COMMUNITY DEVELOPMENT DEPARTMENT
501 Delta Ave ♦ Marysville, WA 98270
(360) 363-8100

Re: Hsiao Short Plat – *Technical Review 2*
File #SP22-004

RE: Hsiao Short Plat, File# SP22-004
Preliminary Short Subdivision of 1.14 acres into five (5) single-family detached lots
4100 81st Place NE & Parcel # 00550600001200, 00550600001300, 30052100314700

DRAINAGE & GRADING PLAN

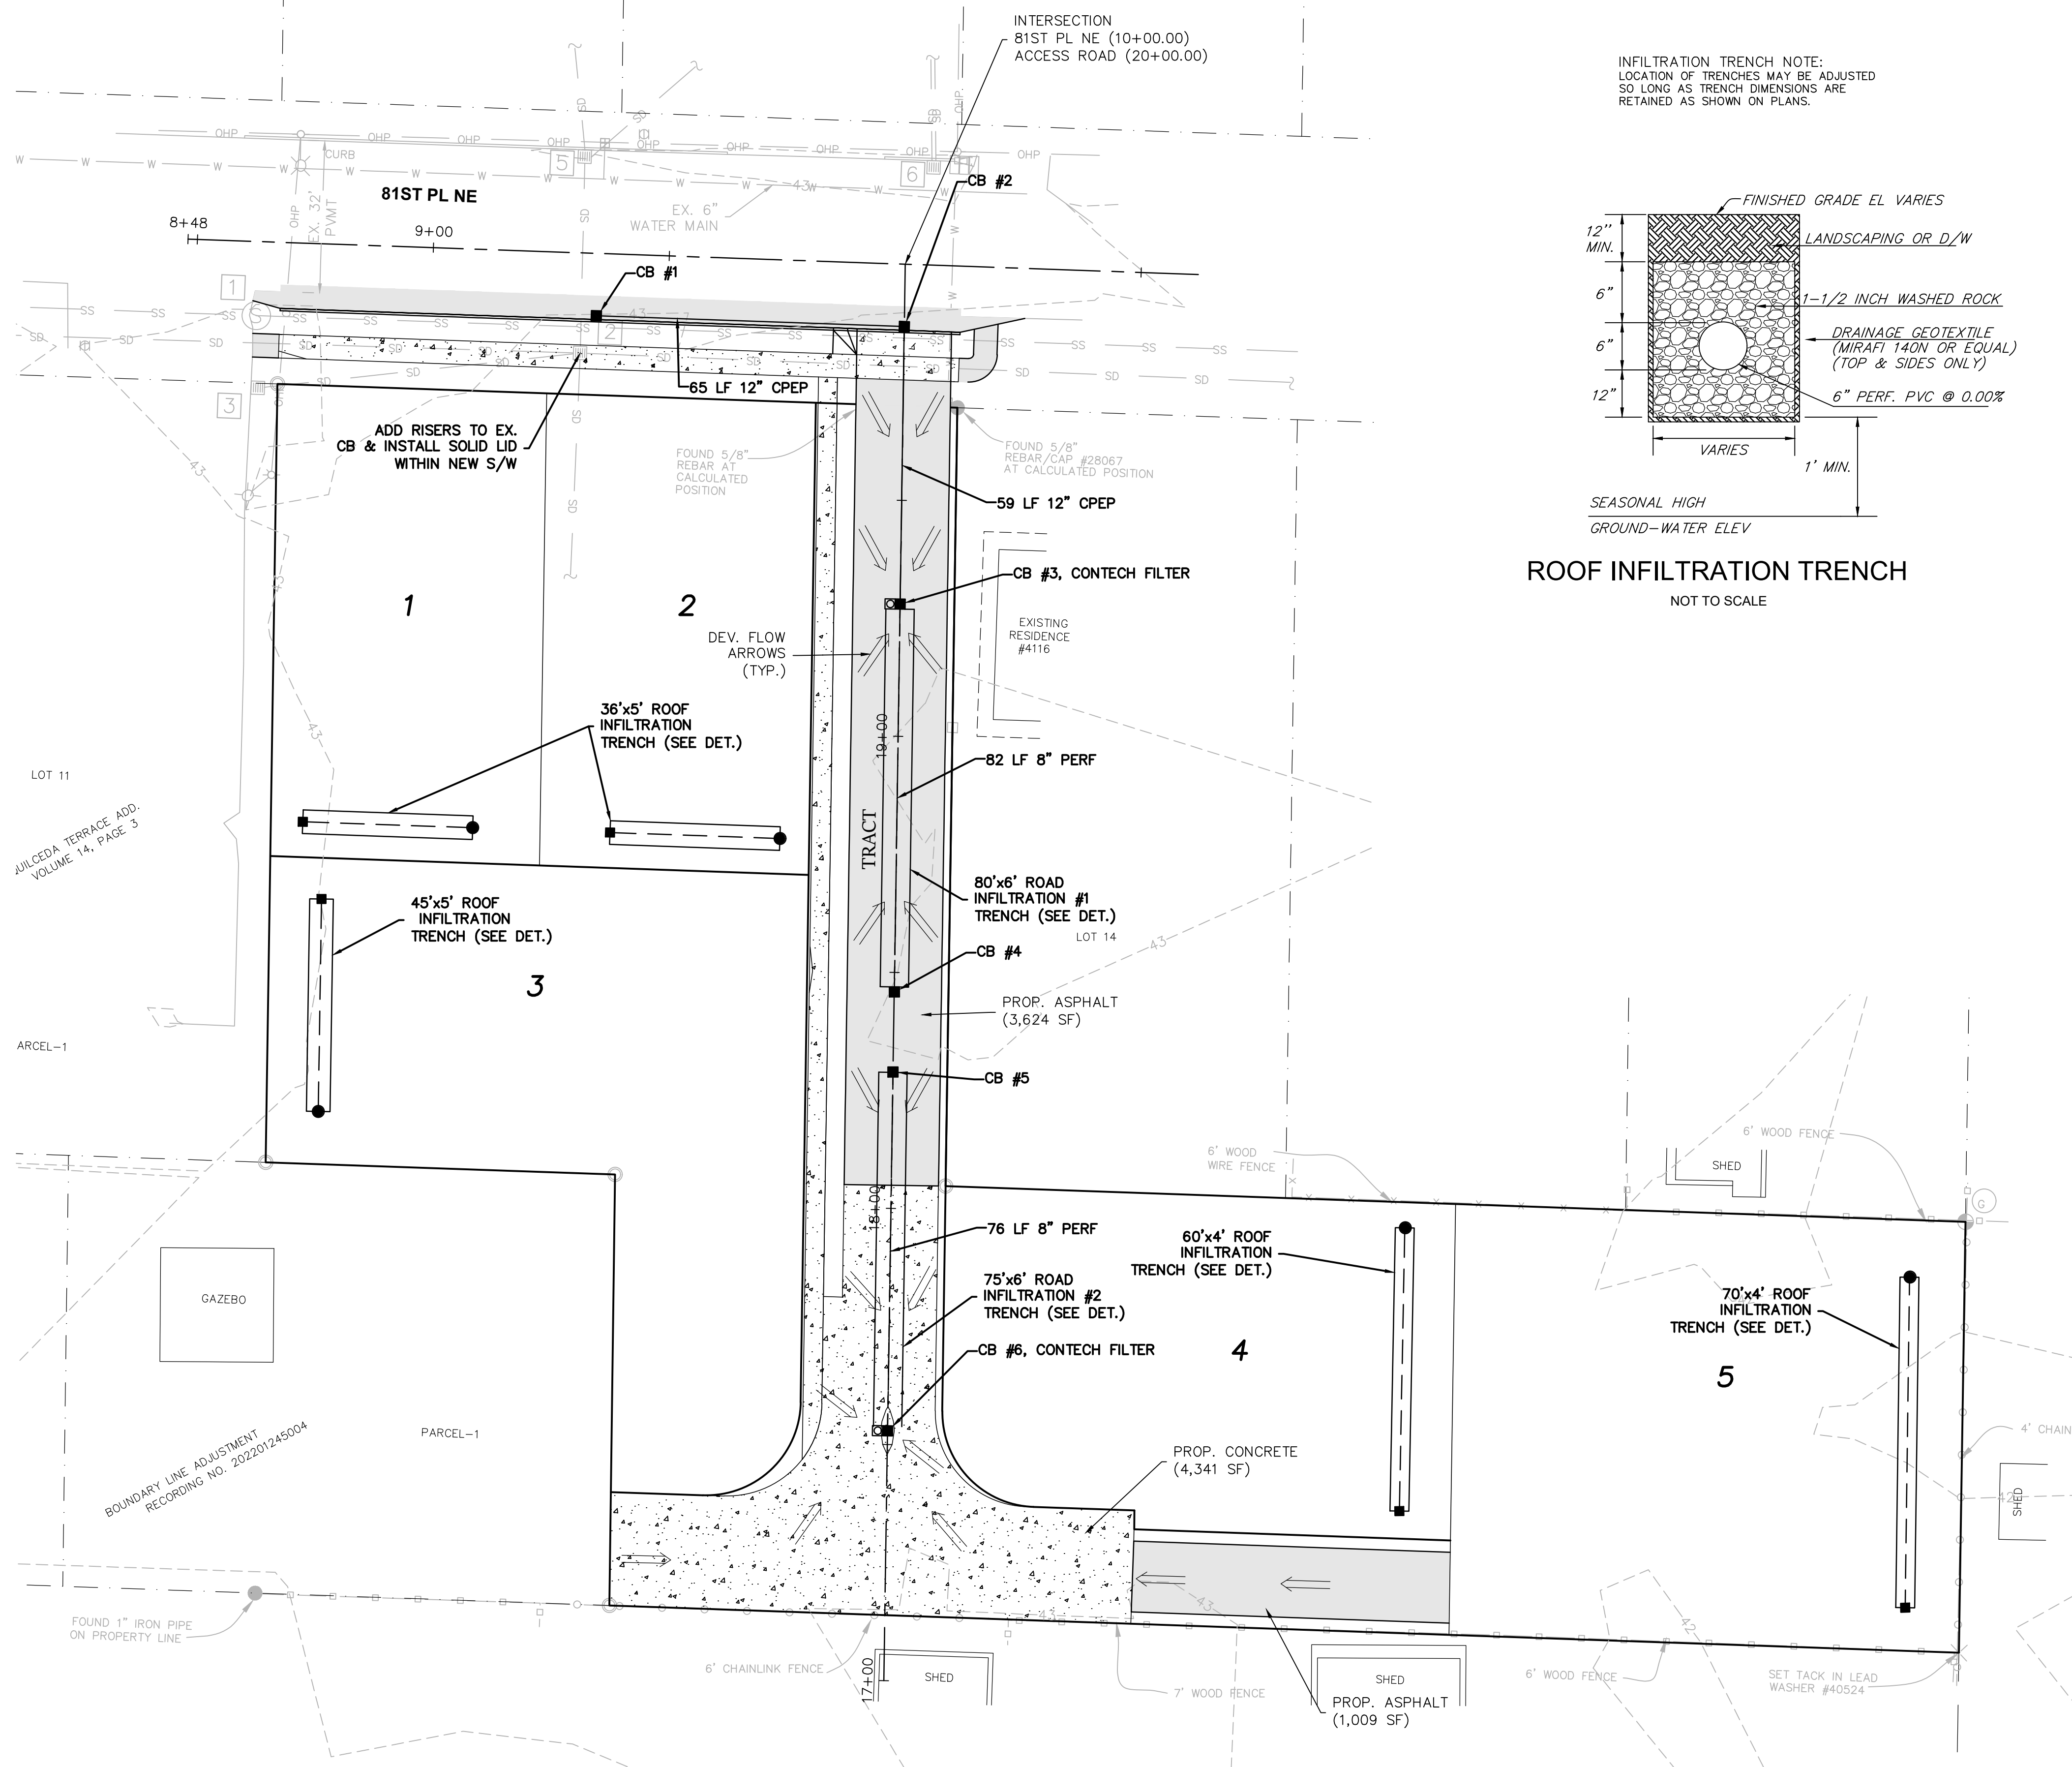
- i. The water and the sewer on site are both main lines requiring easements. The city does not want the infiltration trenches encroaching on each utility easement. The infiltration trenches should not be located within the easement to inhibit maintenance of those utilities. Perhaps the engineer could consider located the gravel trench beds within the flag pole of lot 3.

ACCESS ROAD CENTERLINE PROFILE

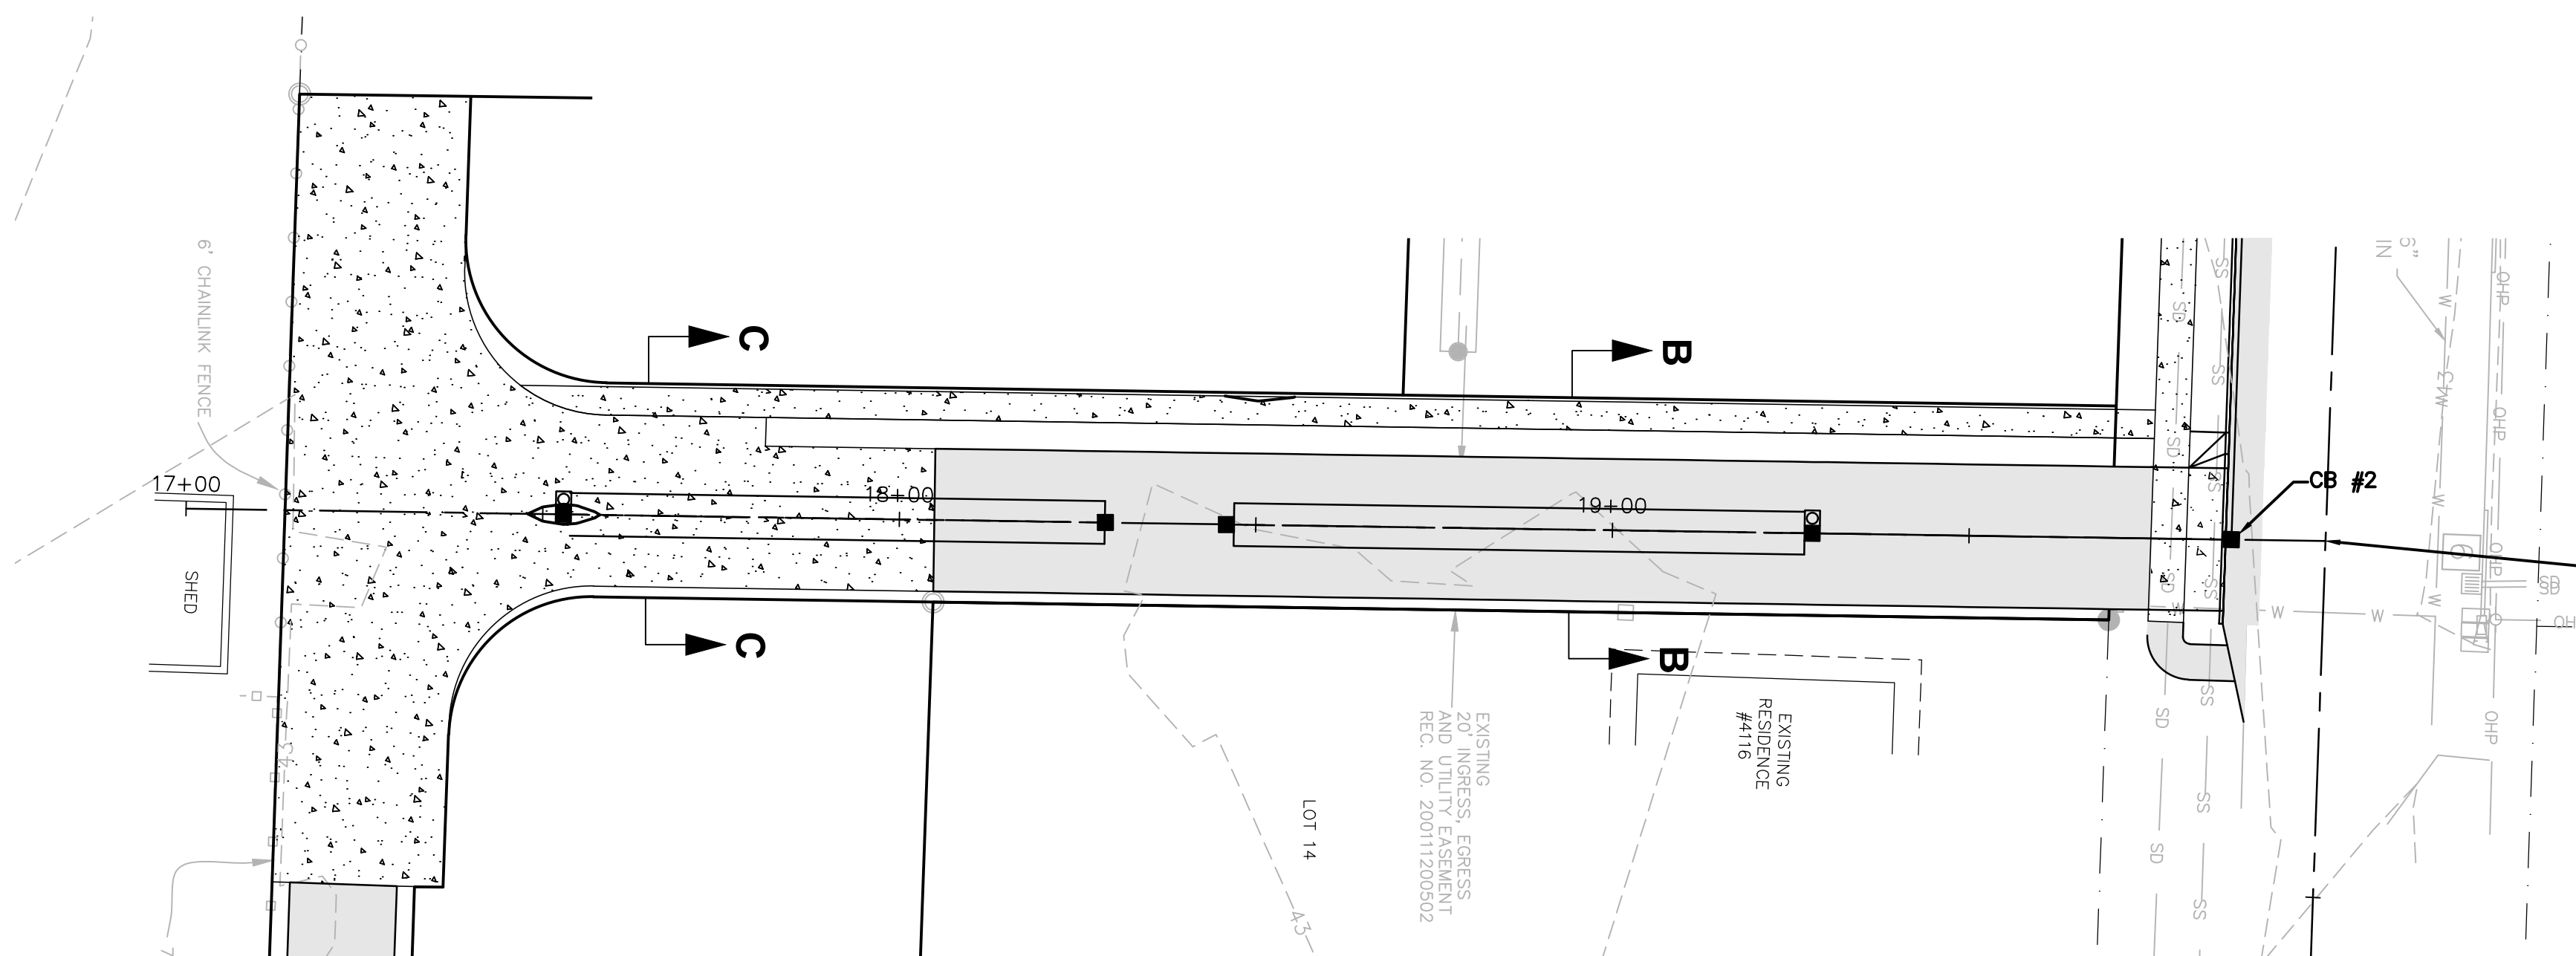
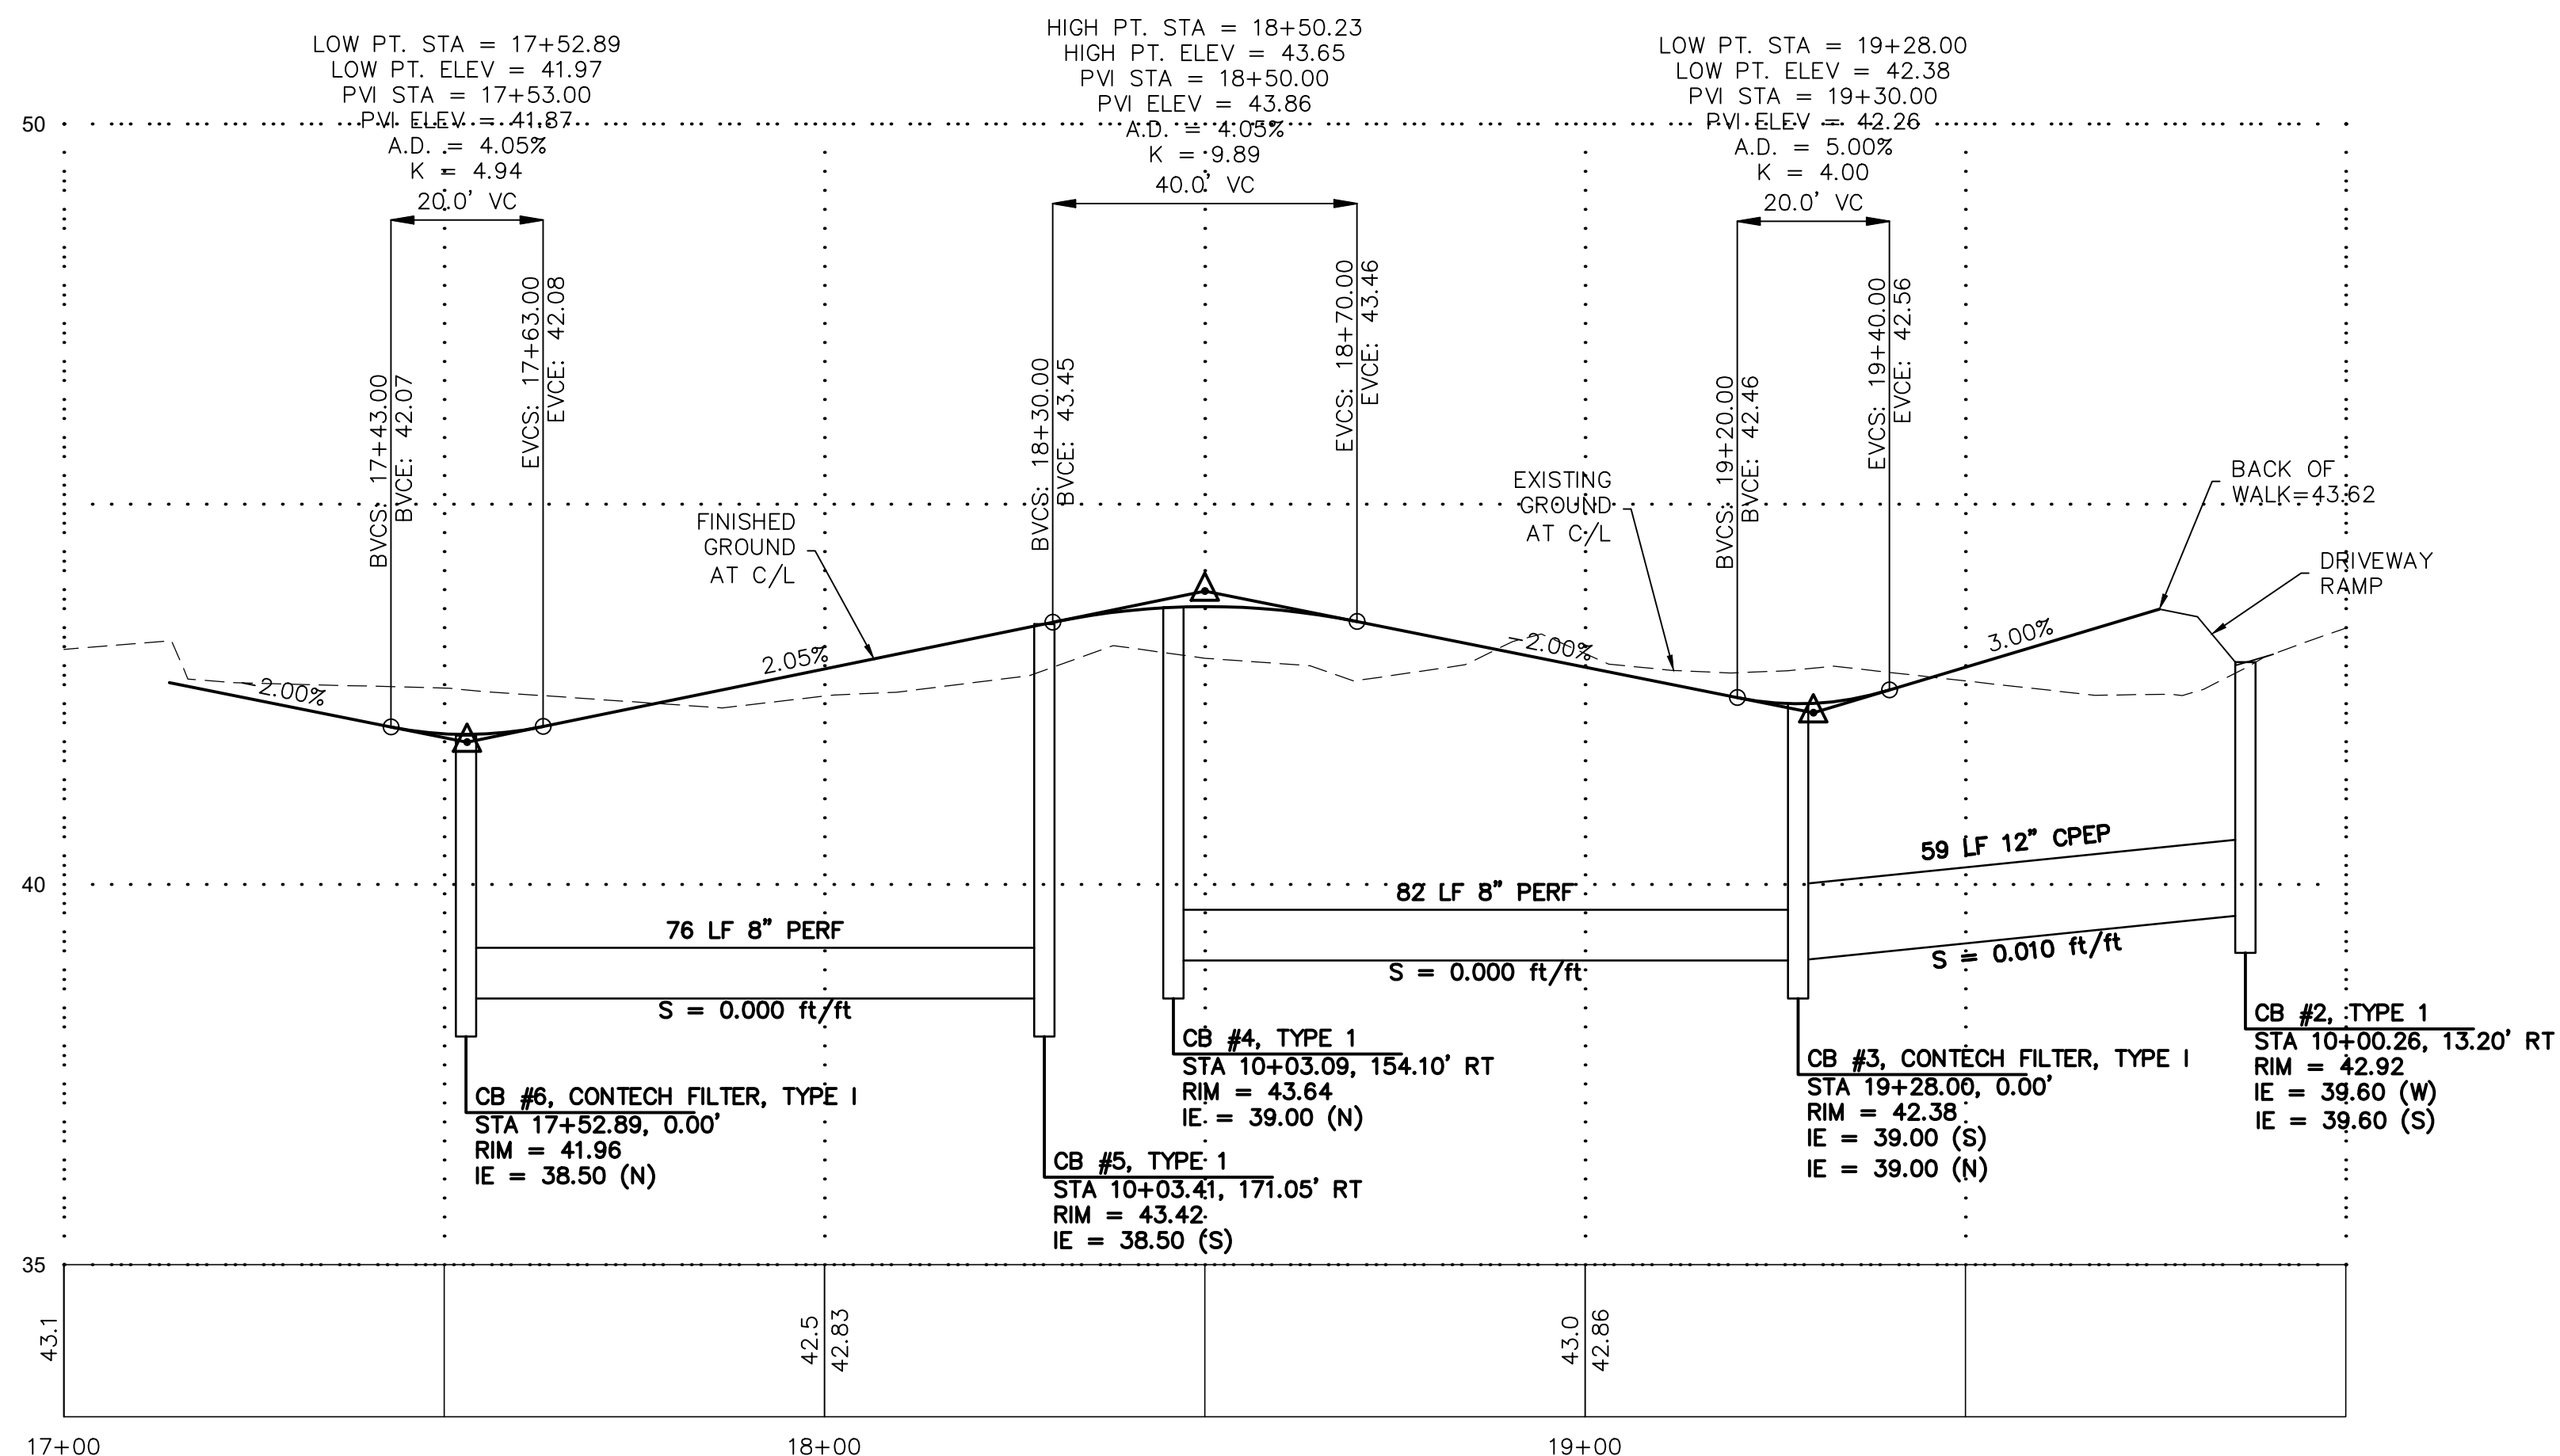
2. The portion of the hammerhead turnaround and accesses to Lots 4 & 5, beginning at the northern property boundary of Lot 4, shall be constructed with scored concrete, paving blocks, bricks, or other ornamental pavers to clearly indicate that the entire surface is intended for pedestrians as well as vehicles. A portion of the proposed access to Lot 5 still shows as asphalt. This will be a condition of preliminary SP Approval

3. Provide a detail on the civil construction plans demonstrating adequate on-site turnaround on Lot 5, ensuring residents are not required to back out onto the Access Tract. This will also be required to be demonstrated, prior to building permit issuance, and shall be a condition of preliminary SP approval.

3. **The drive aisle be posted "NO PARKING – FIRE LANE" to maintain unobstructed emergency access. This will be also shown on the approved civil plan to identify the required fire lane.**
